Subject: RE: 14-136 Pearl Dental, Angmering

NOTE:
The contractor is to check all site dimensions and levels before work starts.
Do not scale from the drawing. Report any discrepancies.

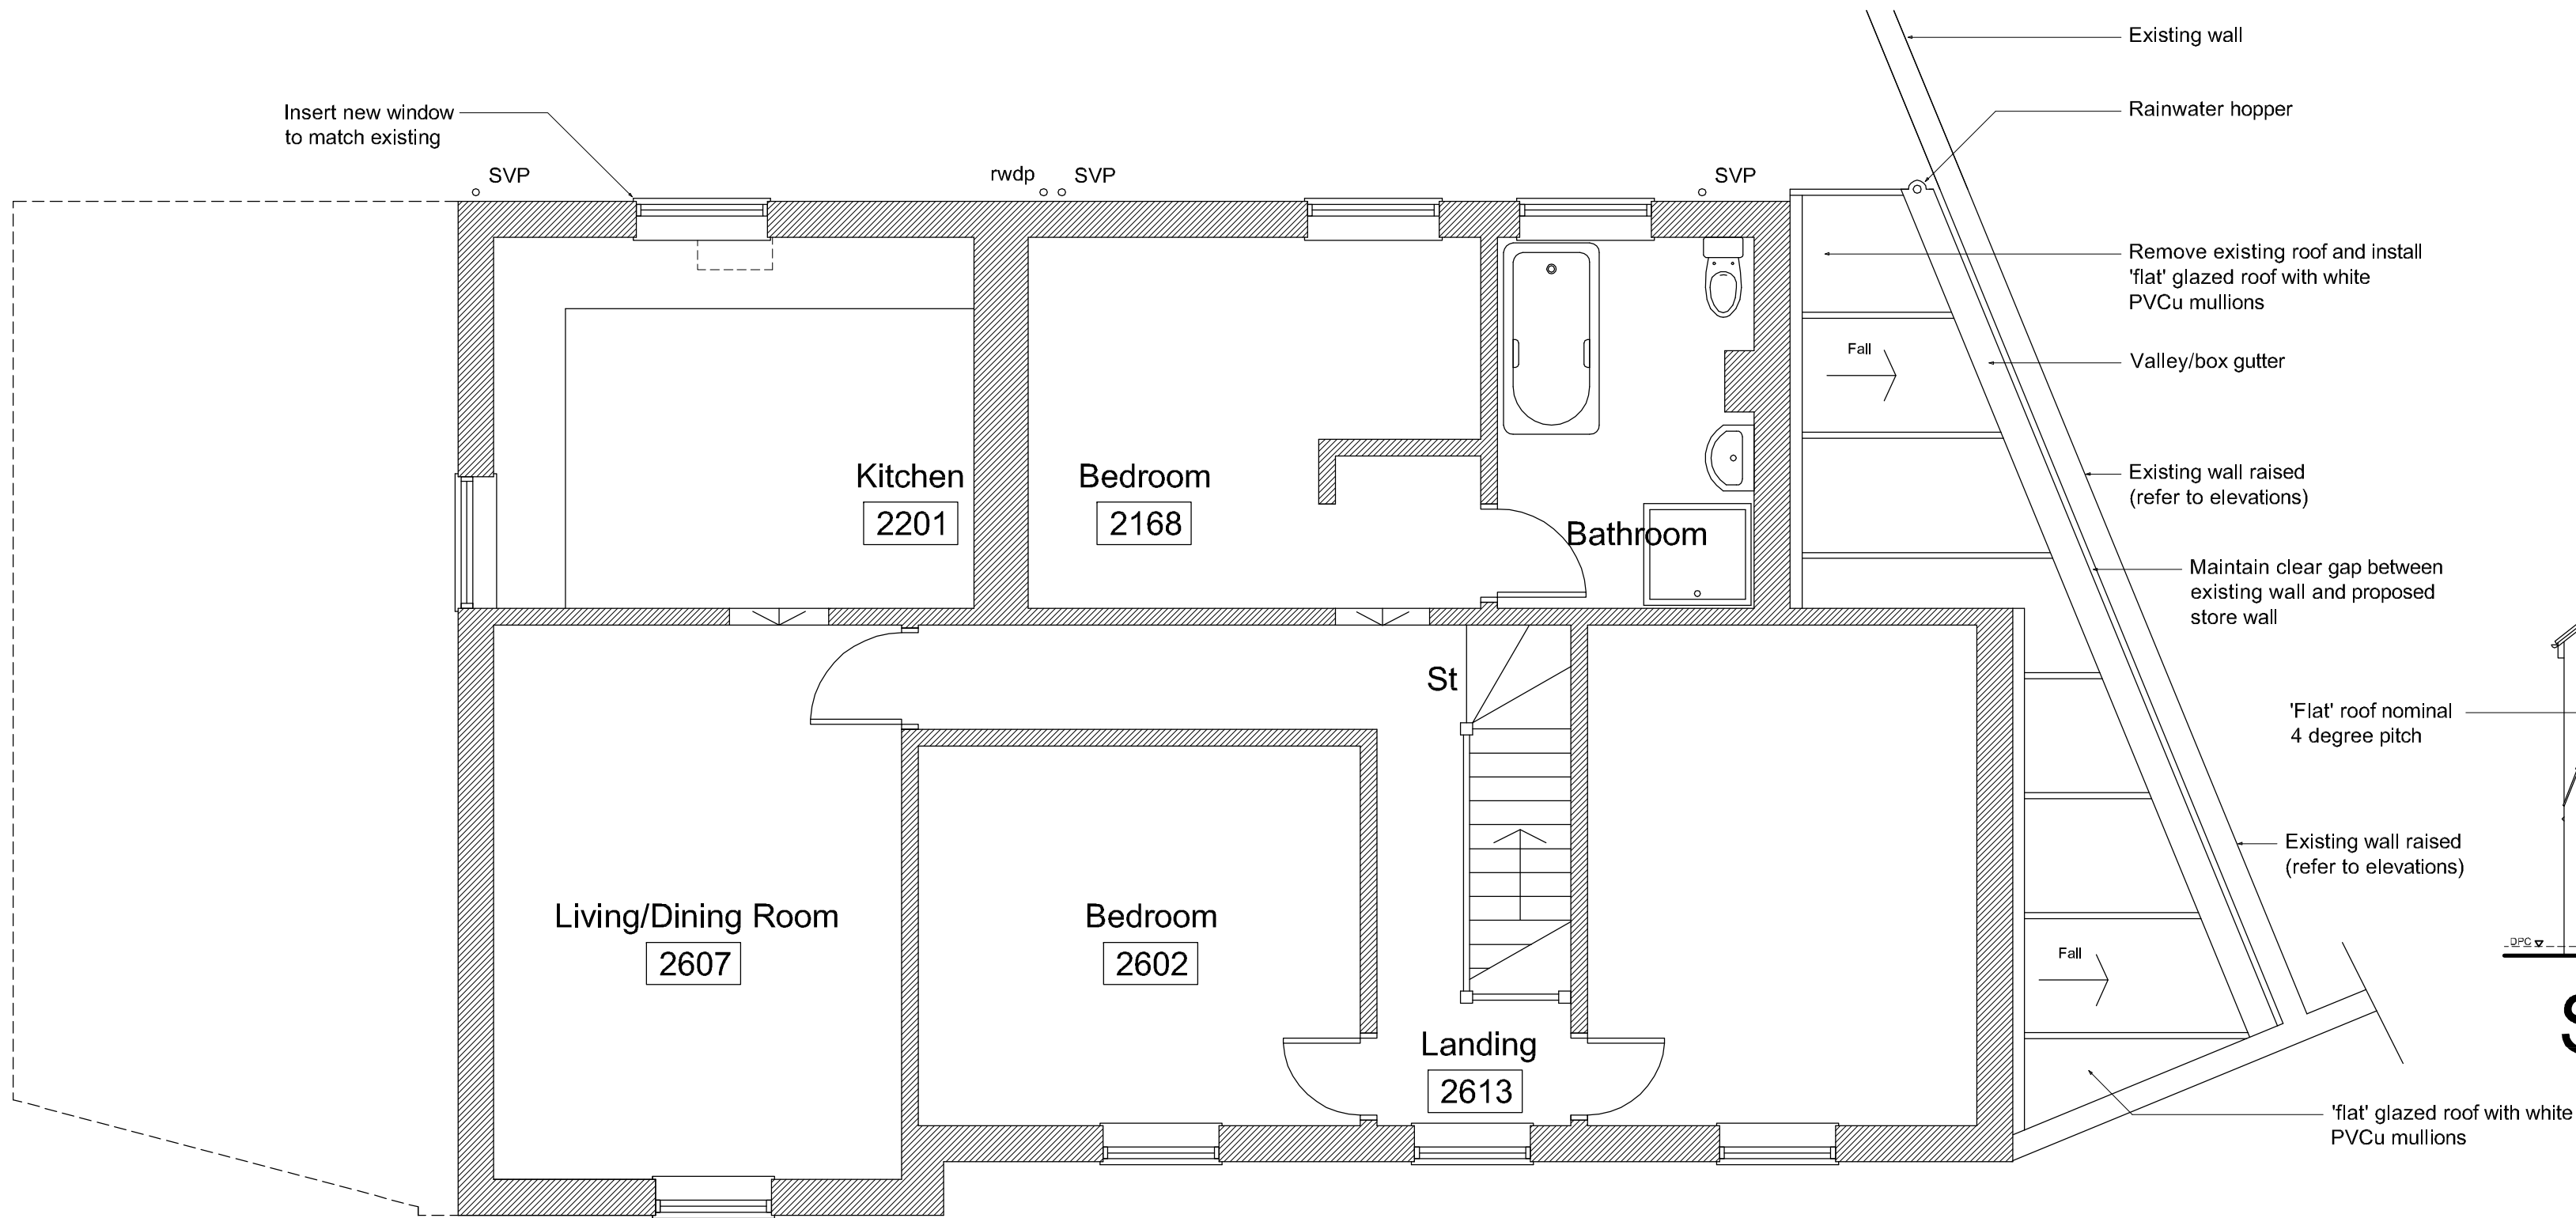
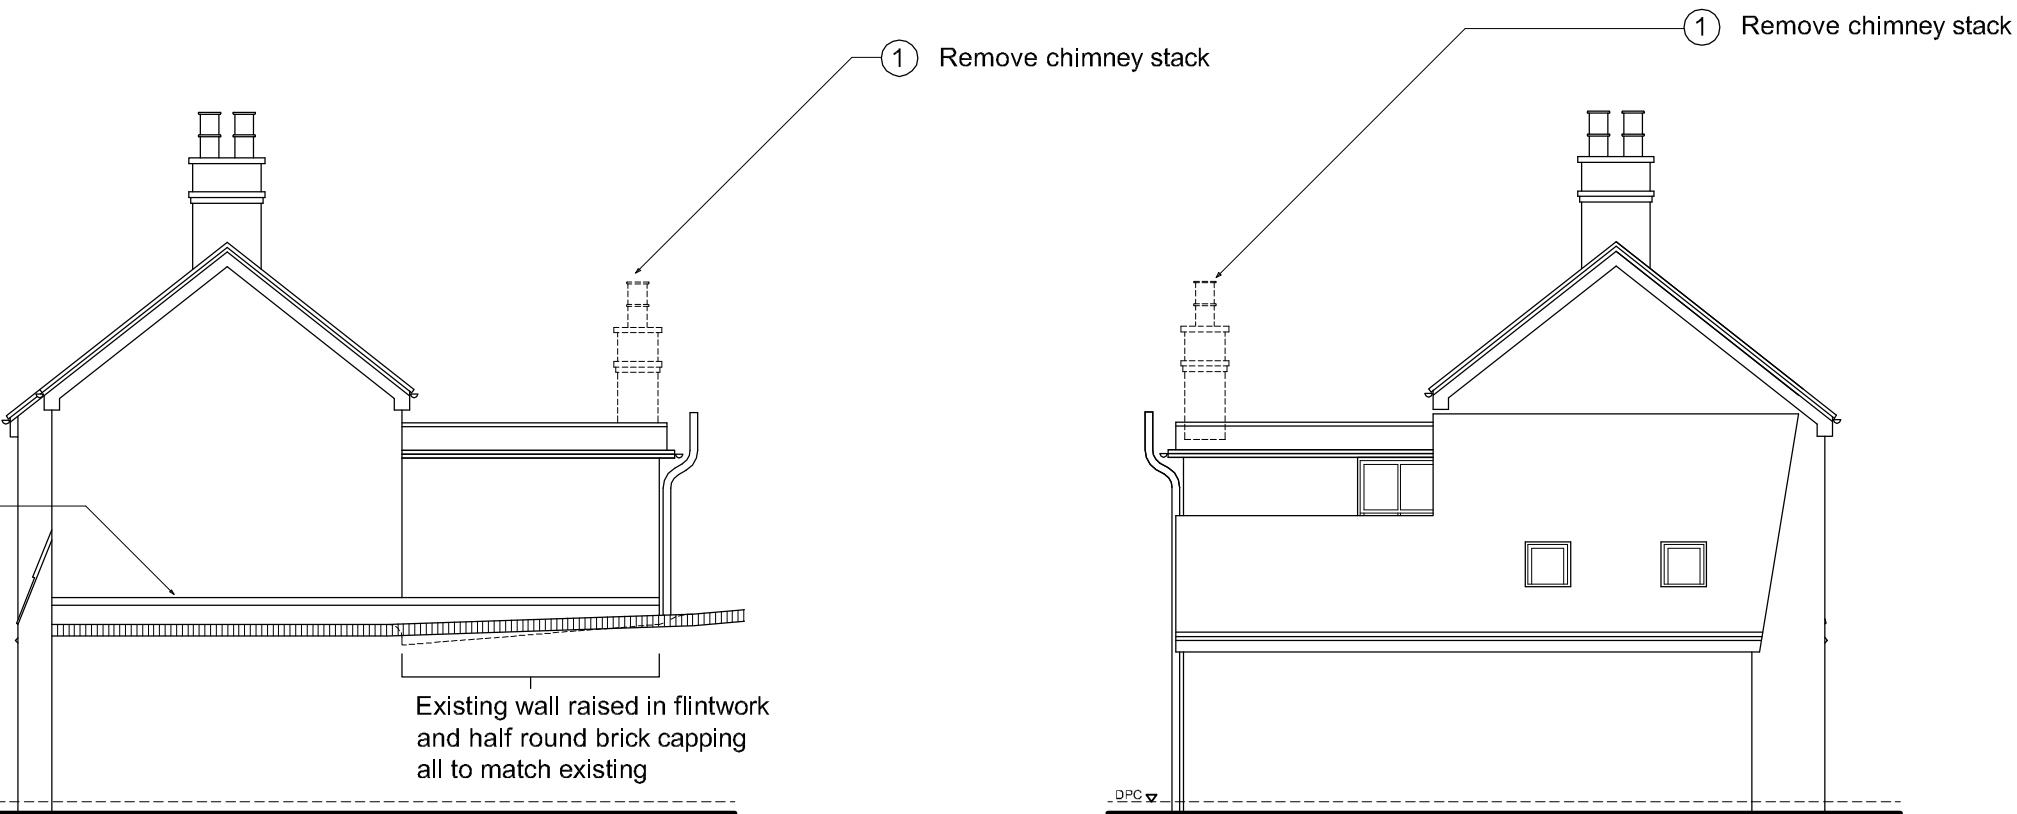
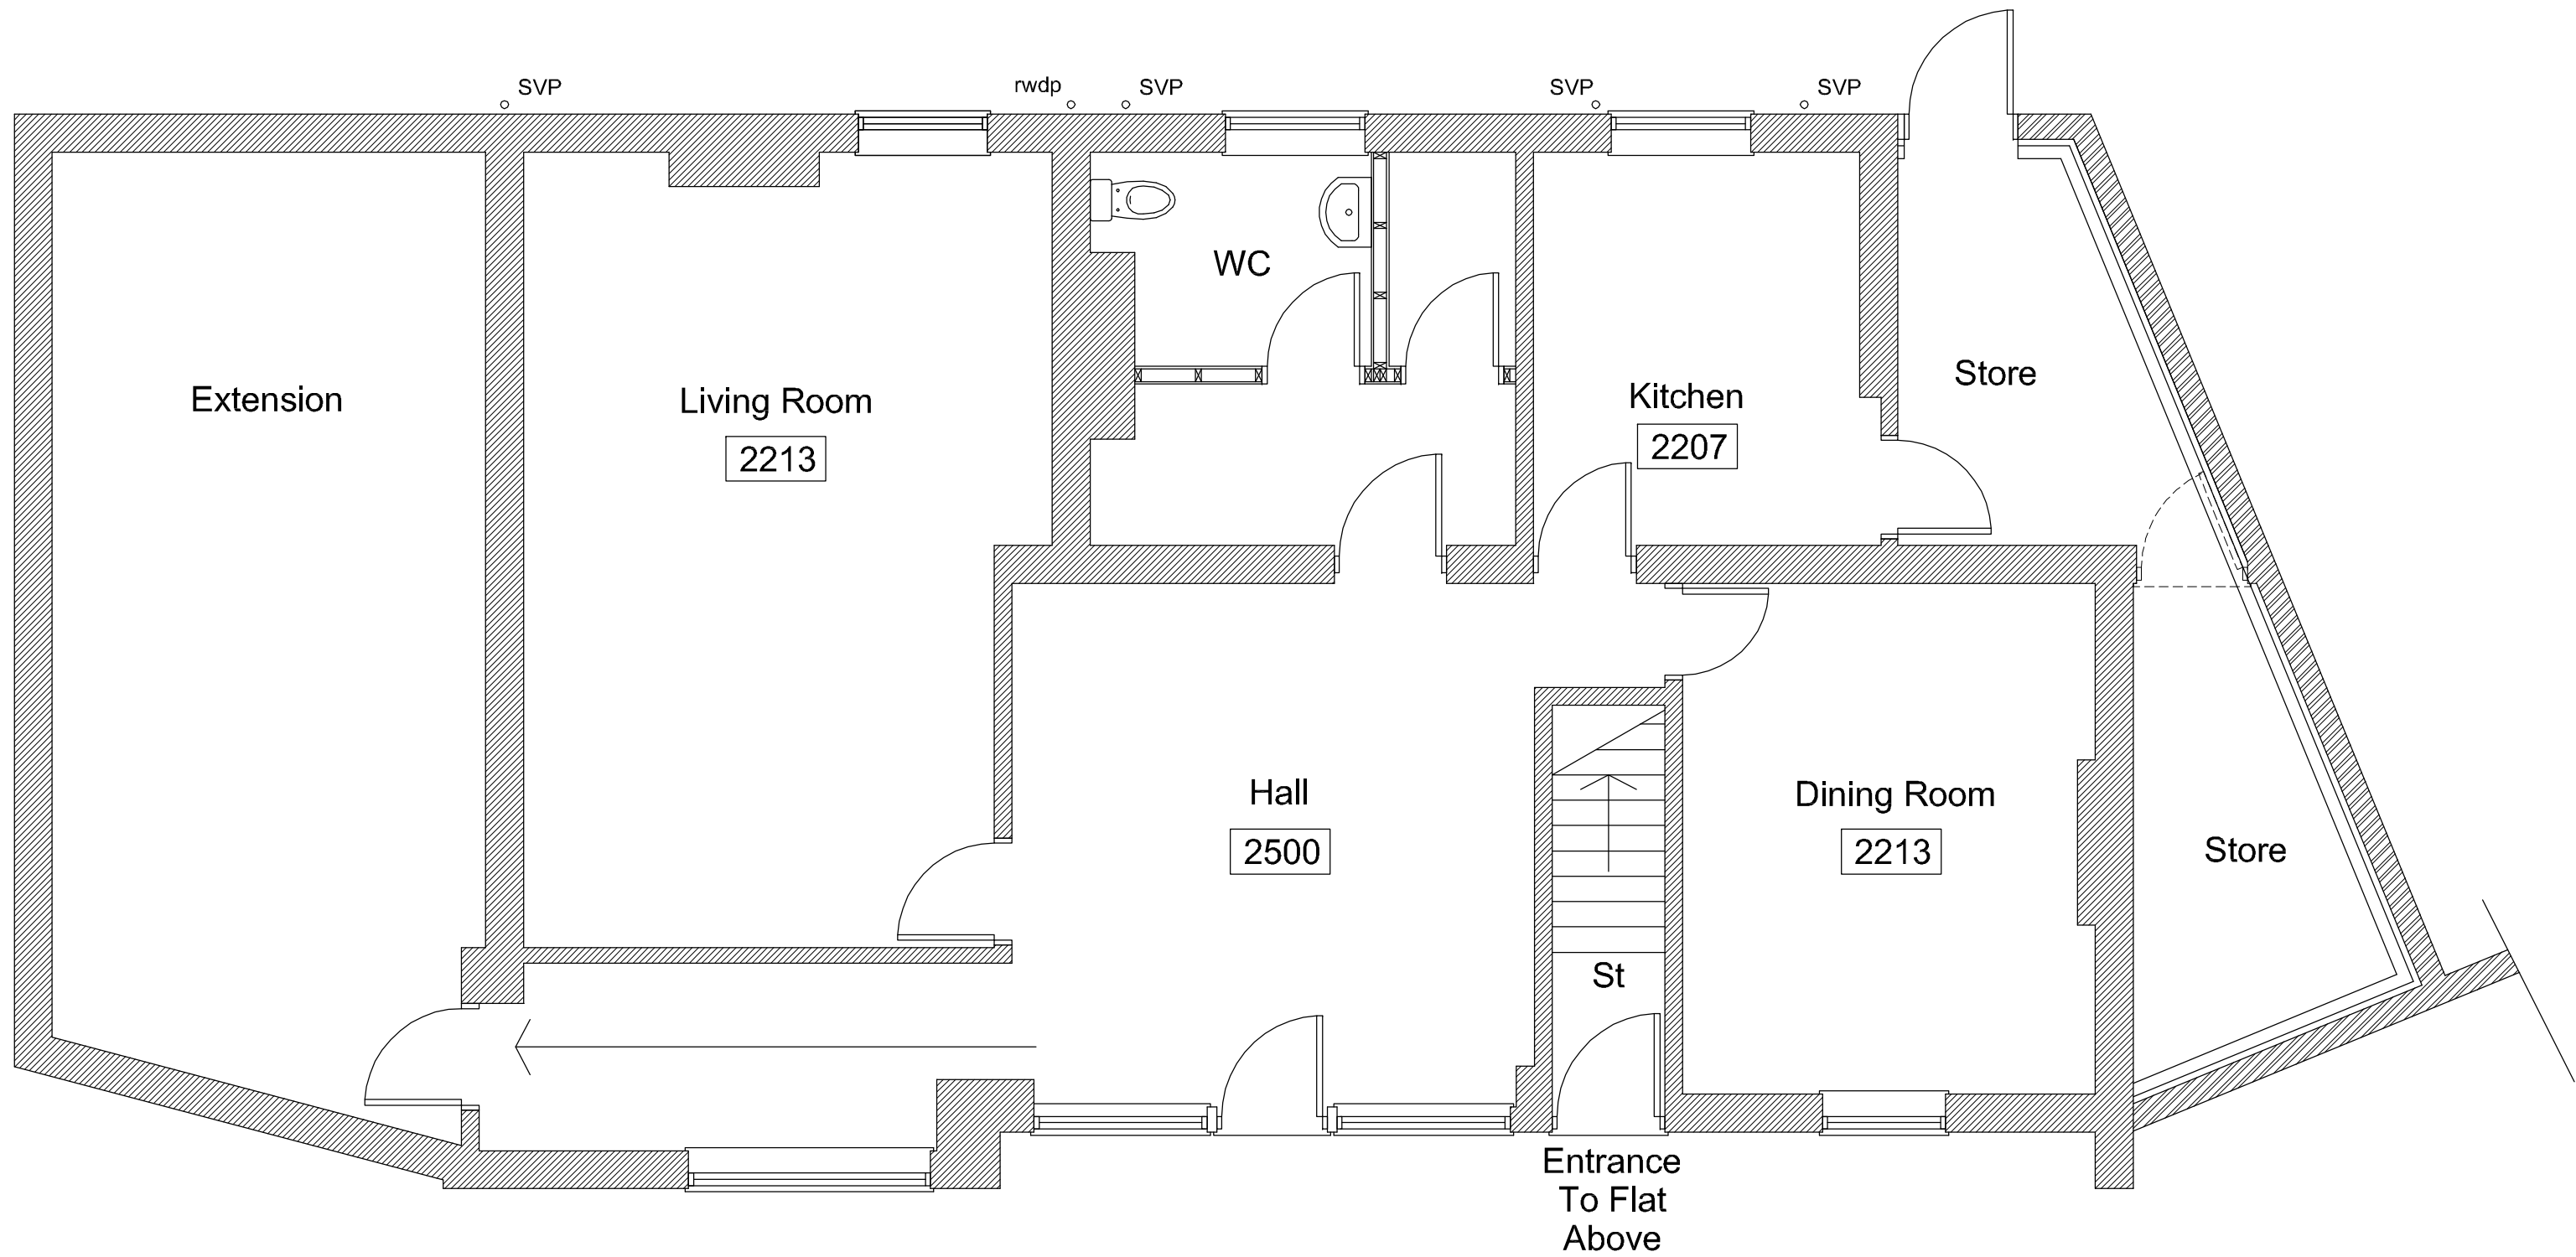
I will be honest and state that I still have reservations regarding the loss of the valley. However, you are able to explain the reasons for the proposal and your belief in the lack of impact as part of the application. The use of quality materials may lessen the impact of the change.

The signage does seem excessive. However, the impact of the front sign could be reduced if the existing sign is to be removed.
